From: Daun Johnson on behalf of Planning.Responses
Sent: 21 September 2026 08:57
To: Planning Scanning
Subject: FW: LU/174/26/PL

From: Jonathan Best <Jonathan.Best@arun.gov.uk>
Sent: 18 September 2026 14:22
To: Planning.Responses <Planning.Responses@arun.gov.uk>
Cc: Hebe Smith <Hebe.Smith@arun.gov.uk>
Subject: LU/174/26/PL

Flint Acre Toddington Lane Littlehampton BN17 7PN.

I have reviewed this application with regards to ecology and Biodiversity Net Gain.

Drawing Title
Existing Site Layout Plan, Proposed Front Elevation indicating Site Levels.

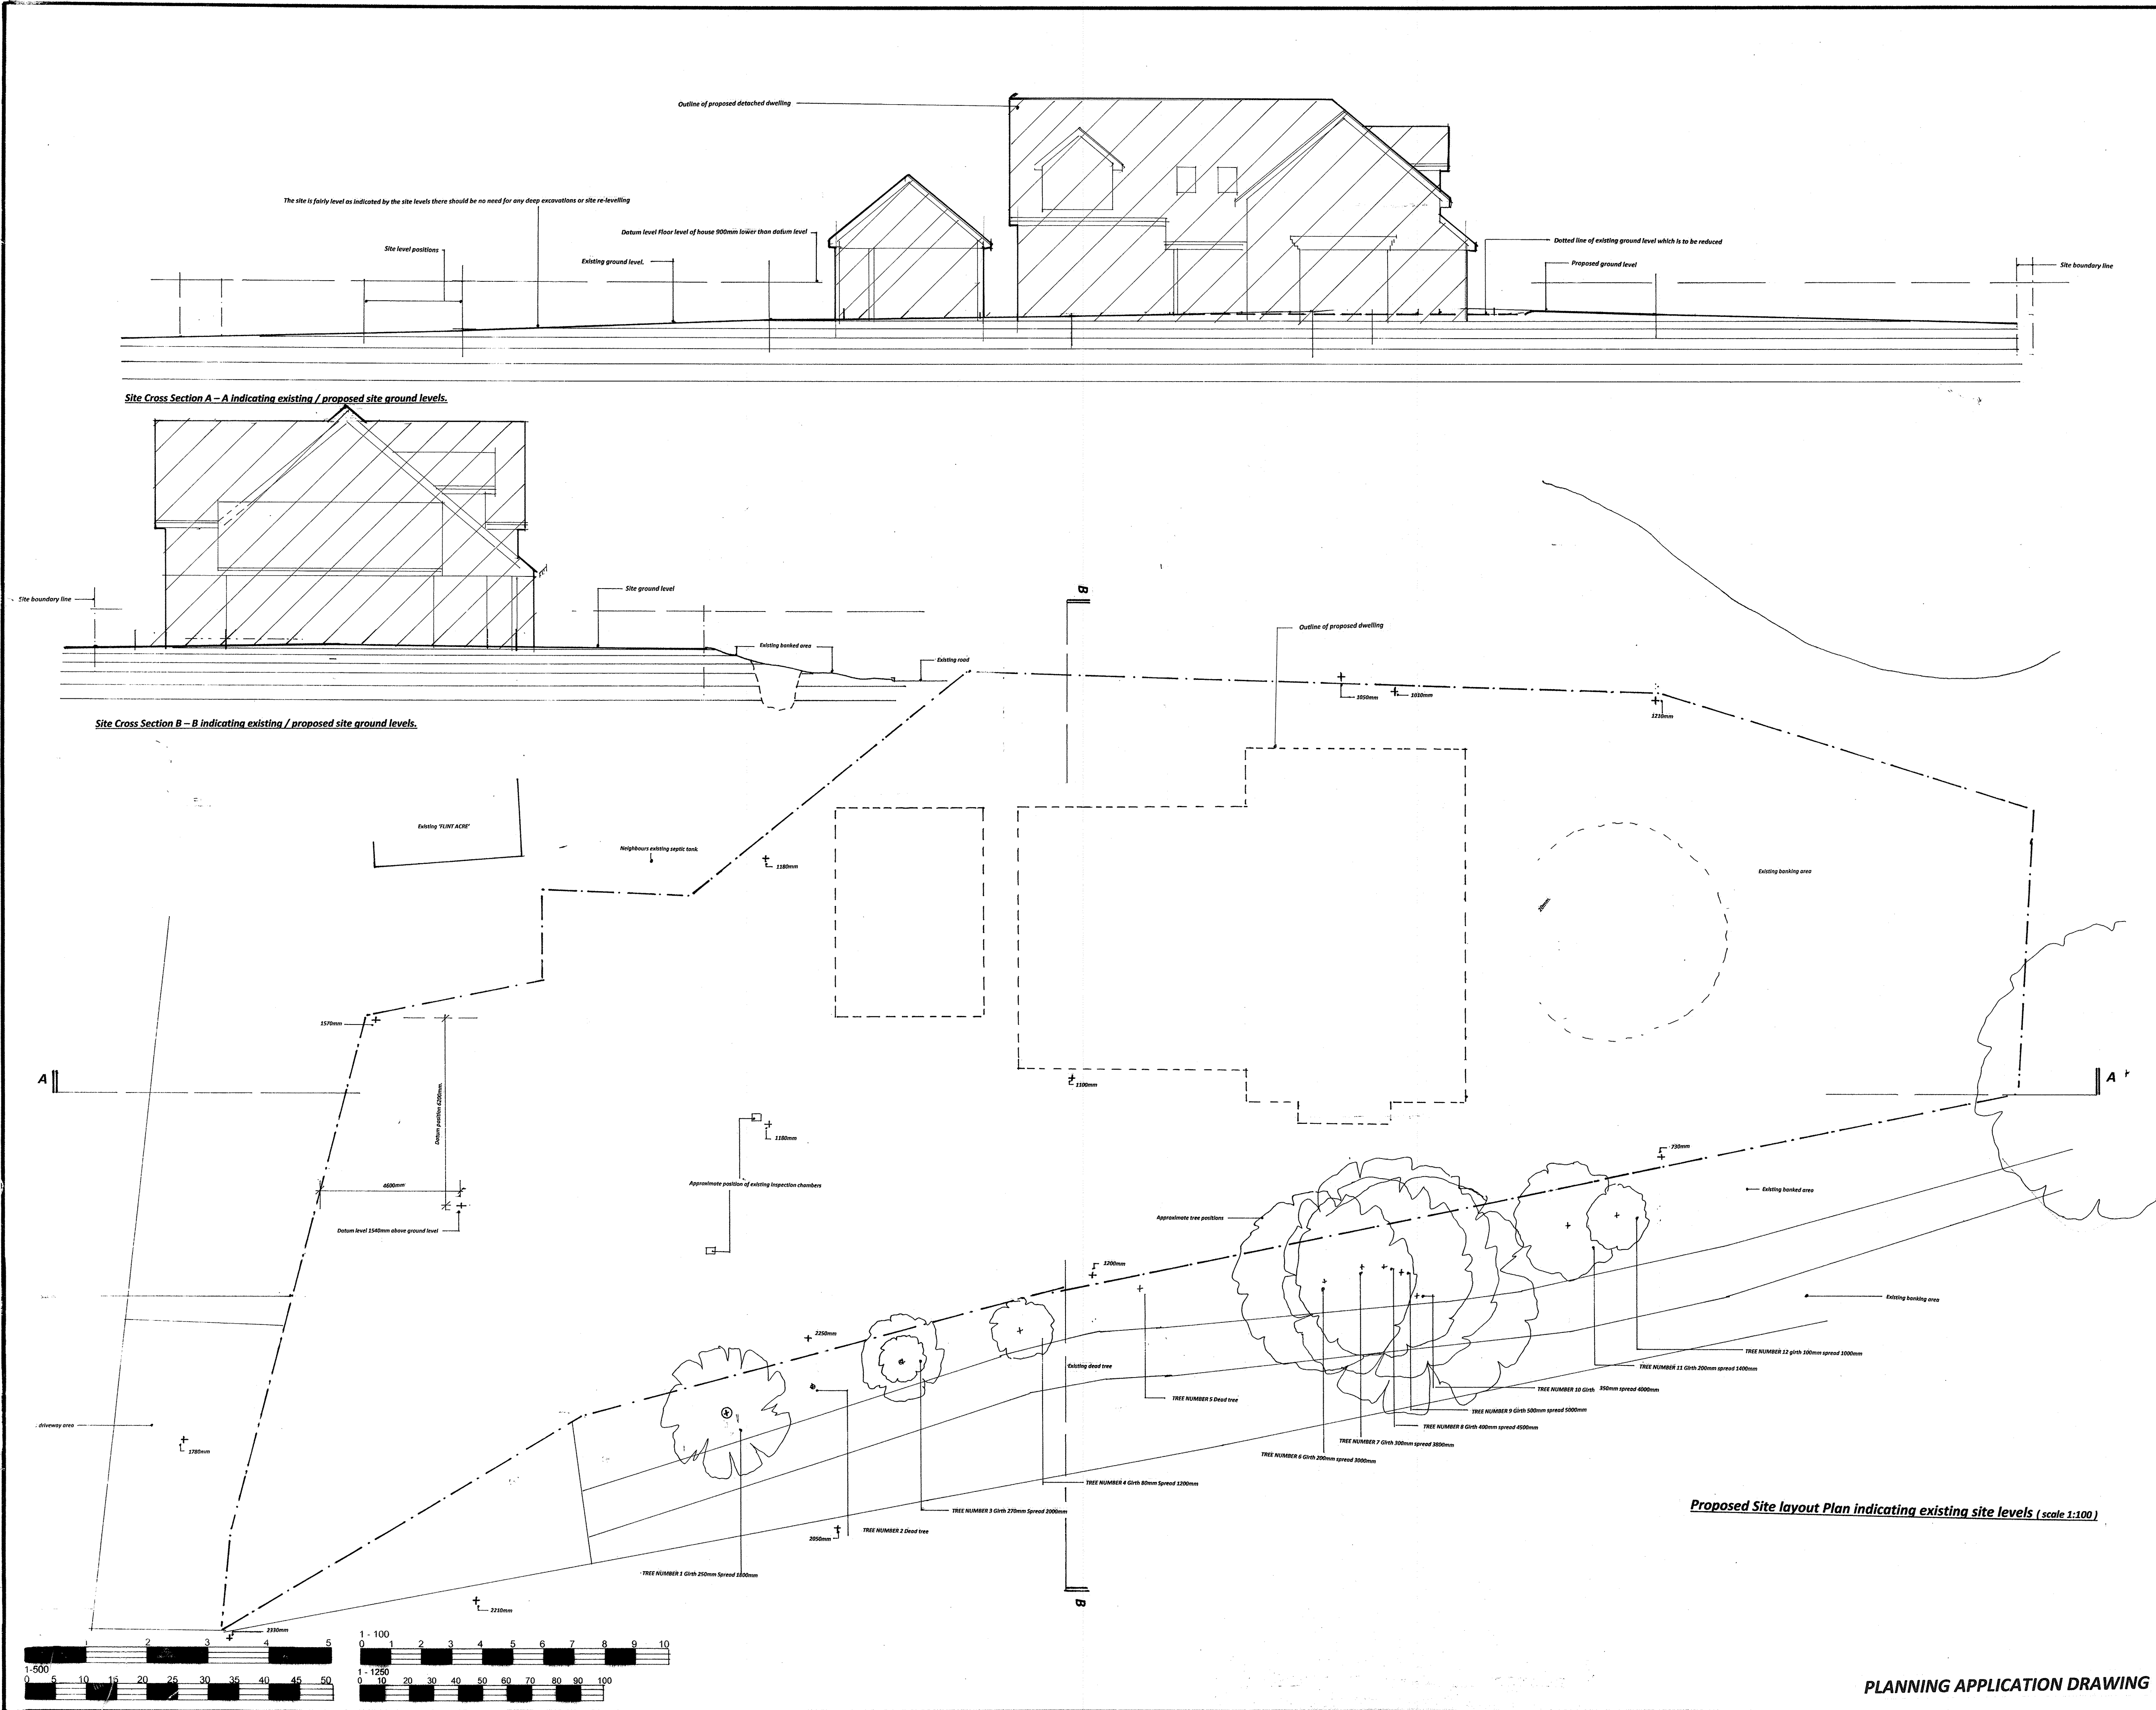
How much of the site will be hard standing?

It is disappointing that none of the native trees onsite are being retained. Considerate design could accommodate the trees present. One of the key principles of the BNG hierarchy is to retain habitat onsite where possible.
